From: Amanda Scholes on behalf of Planning.Responses
Sent: 27 July 2020 08:12
To: Planning Scanning
Subject: FW: FW: FW: Planning Consultation on: BN/57/20/DOC

Please upload onto Ocella the email below which is the further consultation response from **ADC Drainage Engineers** to discharge of condition application **BN/57/20/DOC**.

Condition 6 – Surface Water Drainage Design

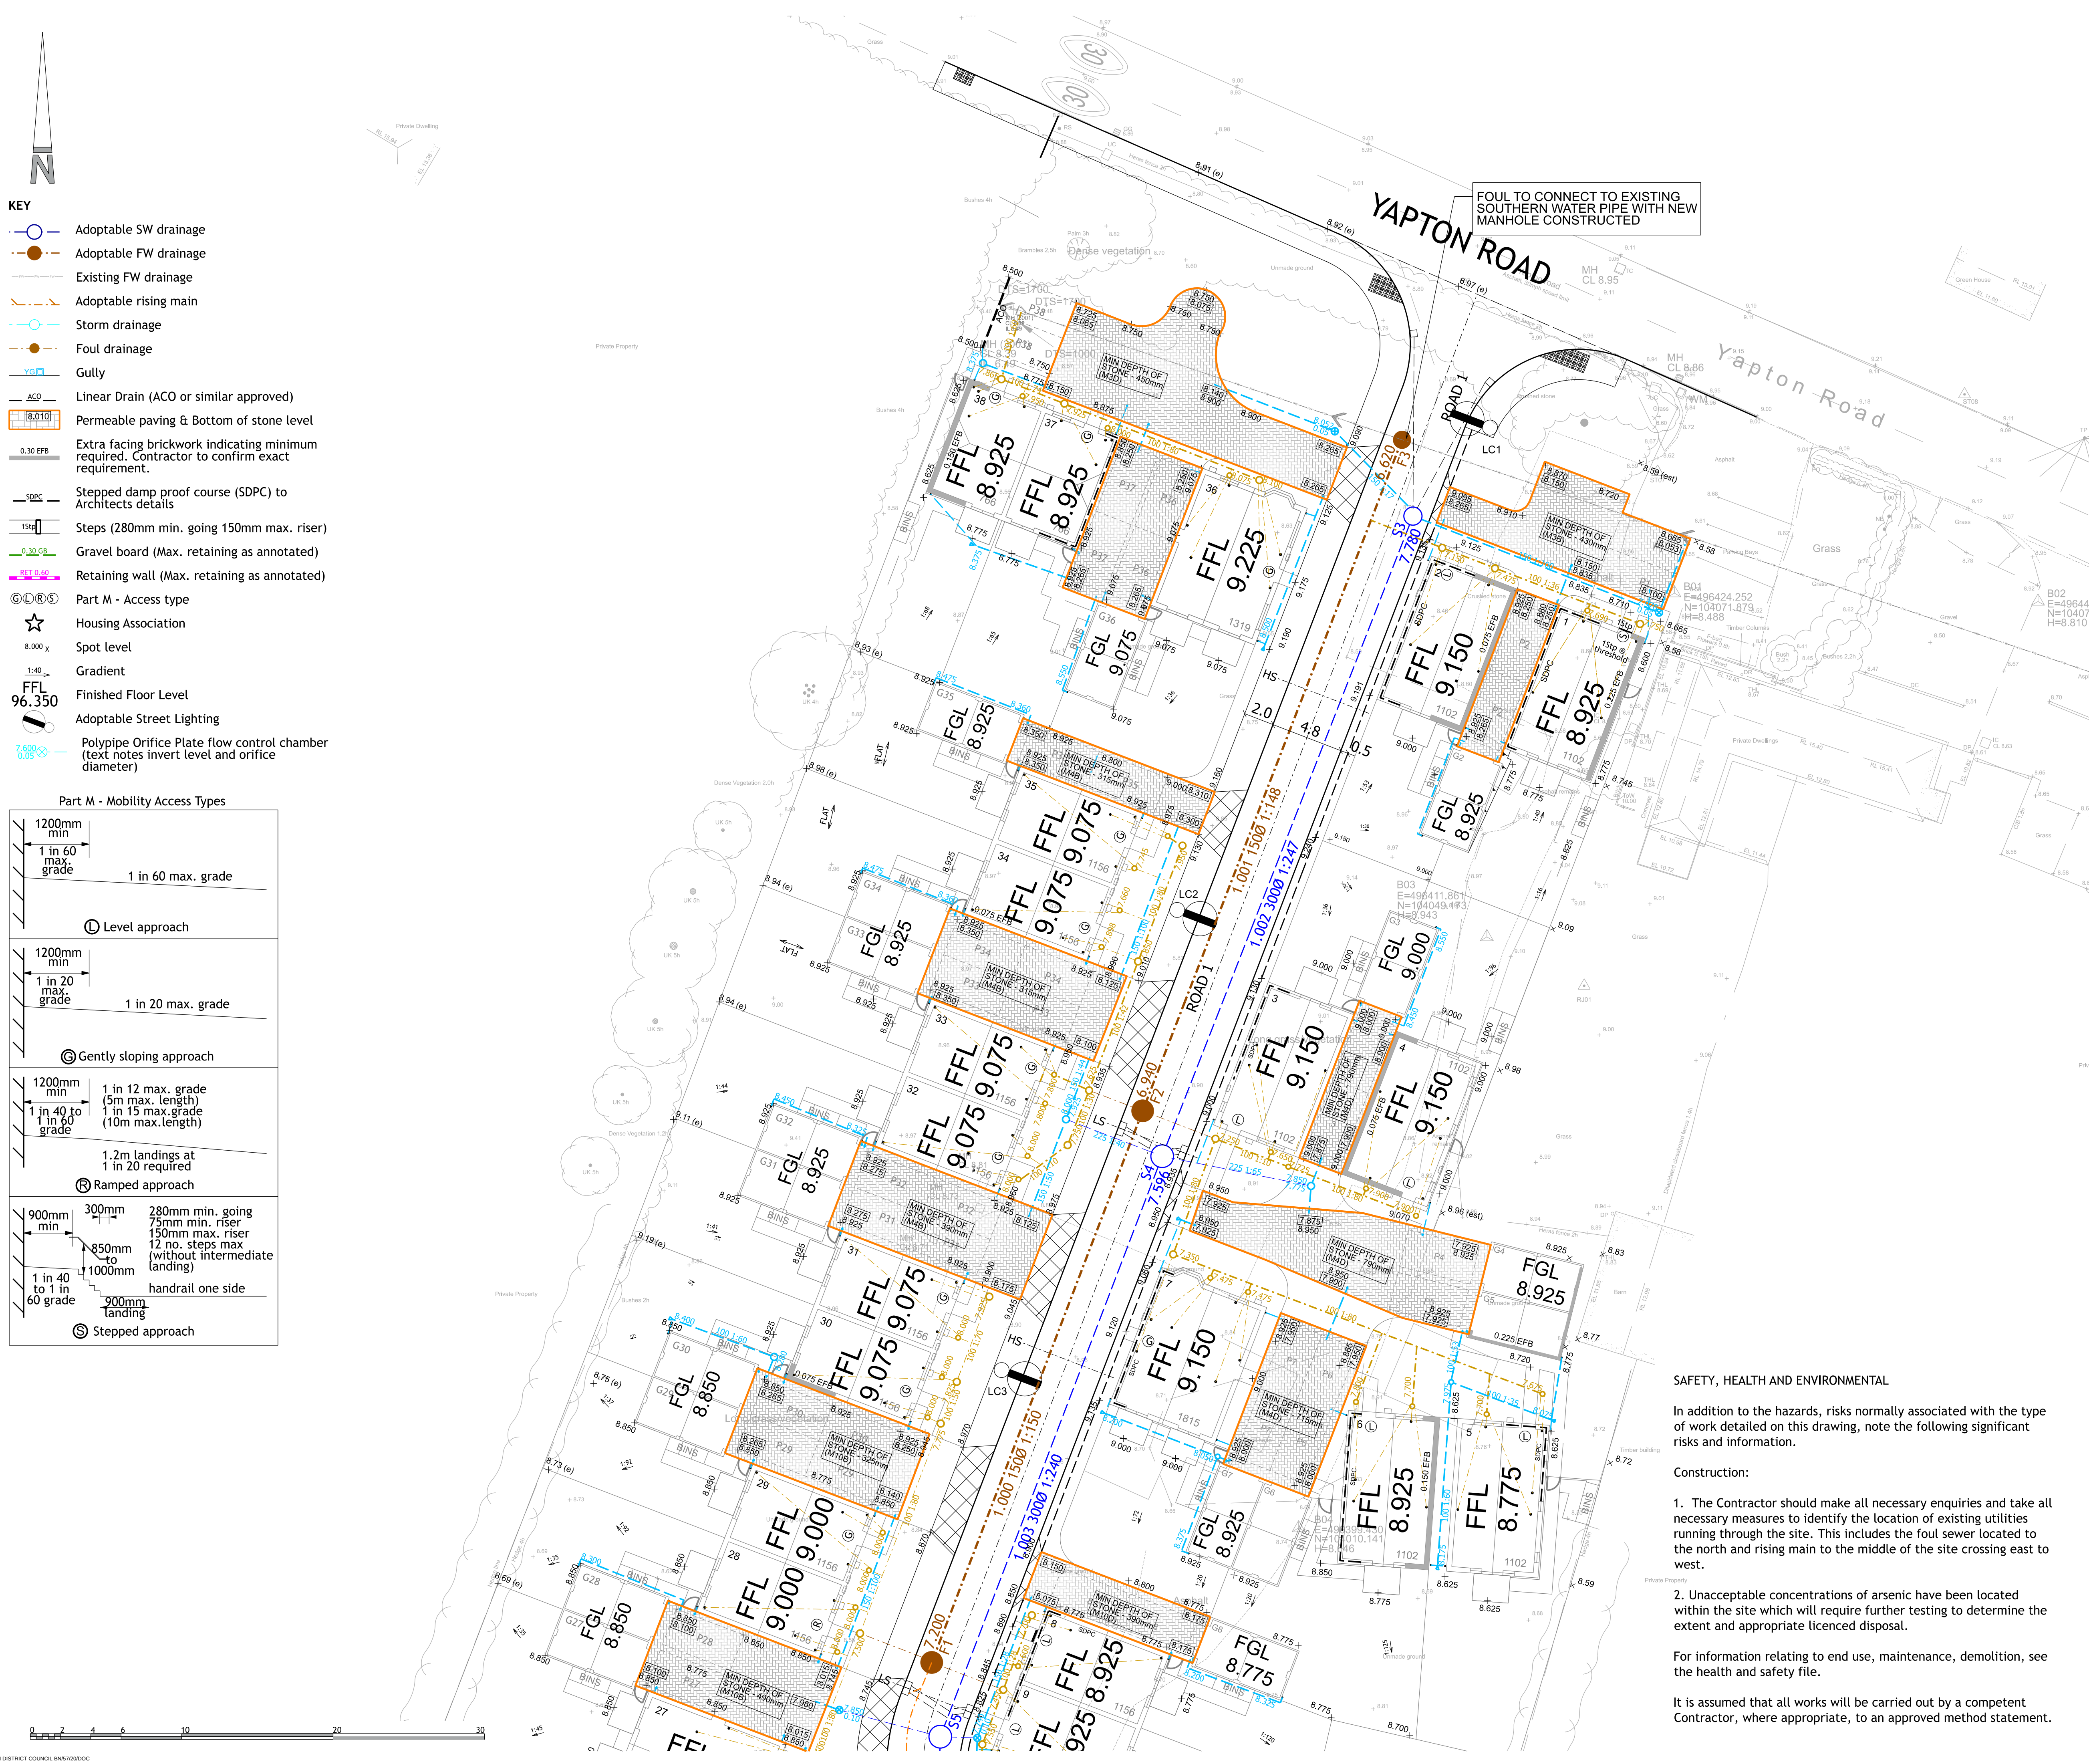
3. No consistency between orifice invert levels on plan and those shown on drawings. Please update calculations or drawings. *Updated drawings/calcs attached.* Updated calculations with surcharged outfall awaited.

4. Porous car park area invert levels and sub base depths in calculations are inconsistent with those shown on plan. Please update calculations or drawings. *Checked and updated. Note in the the manhole number in brackets on the plan depicts the manhole the porous car parks have been modelled on. Also where there are connecting areas, the mean average of the minimum depths have been used.* To be reviewed with revised calculations.

7. Porous car park manhole 8 has a modelled invert level which is far lower than that shown on plan. Please update calculations or drawing. *Checked and updated* To be reviewed with revised calculations.

11. Cover levels must be detailed on plans *Finished ground levels are detailed on the plans. The CL and ILs for the adaptable drainage is shown on MH schedules and longsections. This information is provided and we will not be duplicating the information. MH Schedules were not previously provided as per comment 16 below. These will be reviewed once revised calculations are submitted.*

17. Please detail how ACO drain near hydrobrake connects, this is not clear. *It connects into private lateral as you would expect of private parking bays. Make clear on plans, must be clear to ensure constructed properly.*

17748-BARN-5-SK003 A

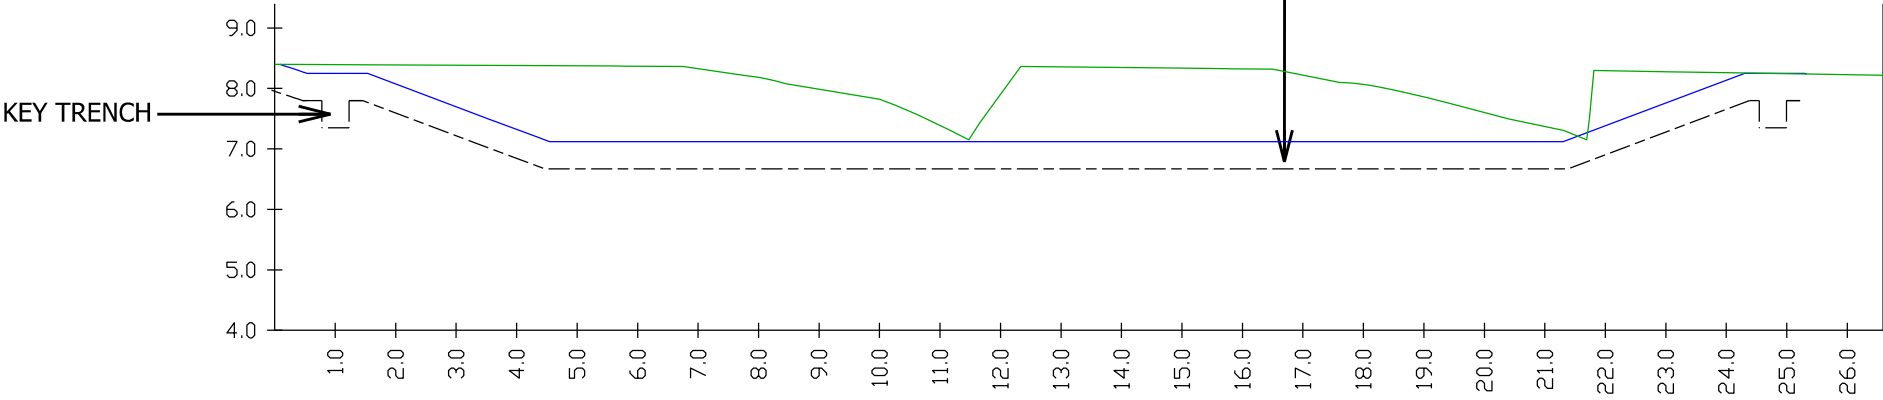
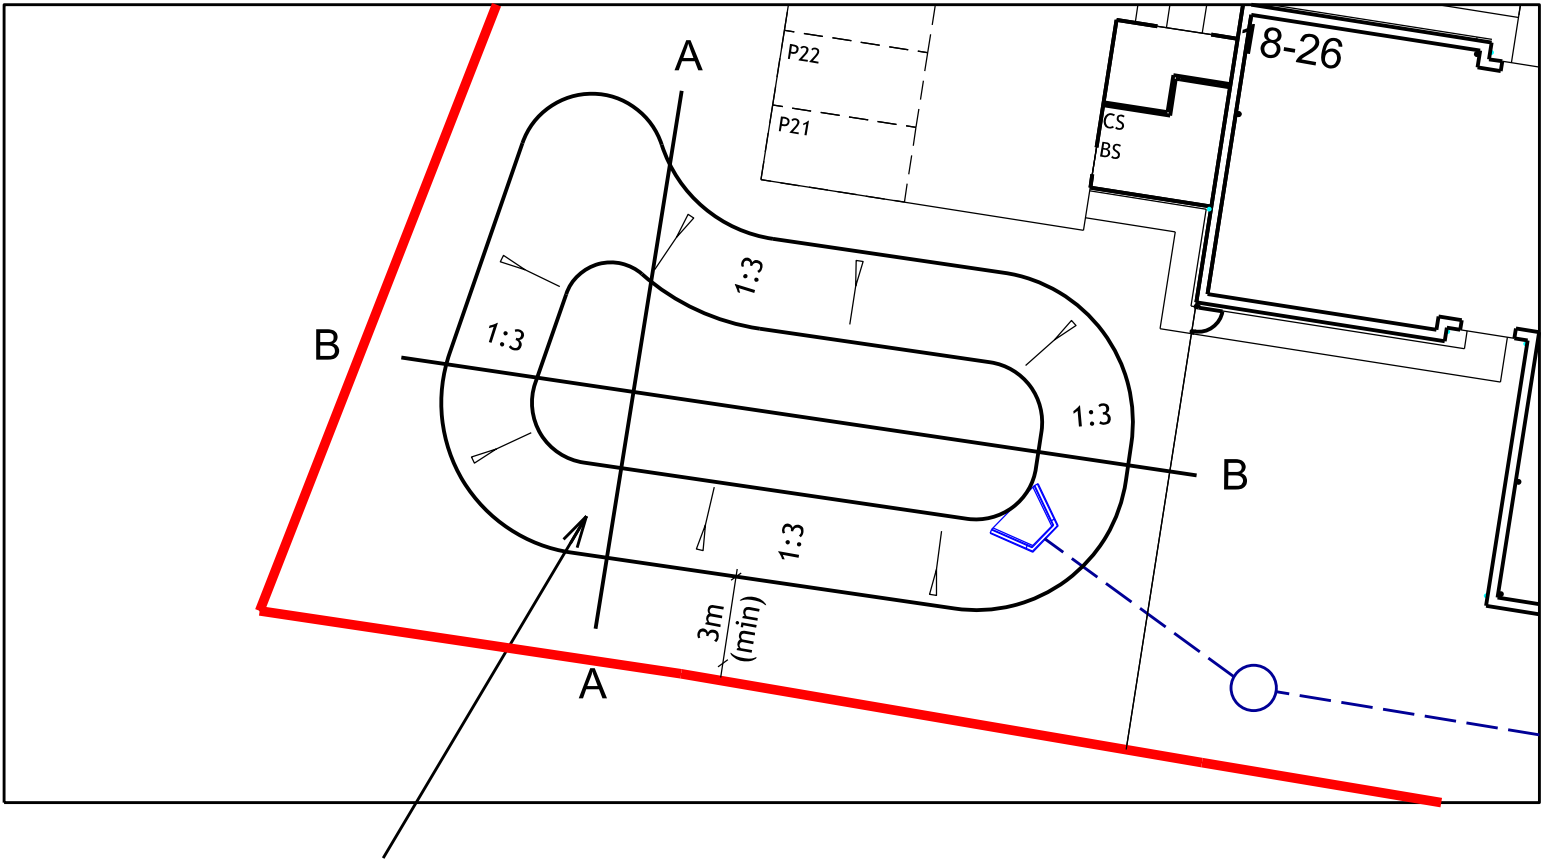
9. Pond cross section construction detail drawings are required- 2 sections required, perpendicular to one another. Details should include liner. *Details of the liner are as per the e-mail correspondence to Paul Cann. Attached Please provide details of what liner is proposed, or a specification that the liner must achieve if a specific liner is yet to be selected.*
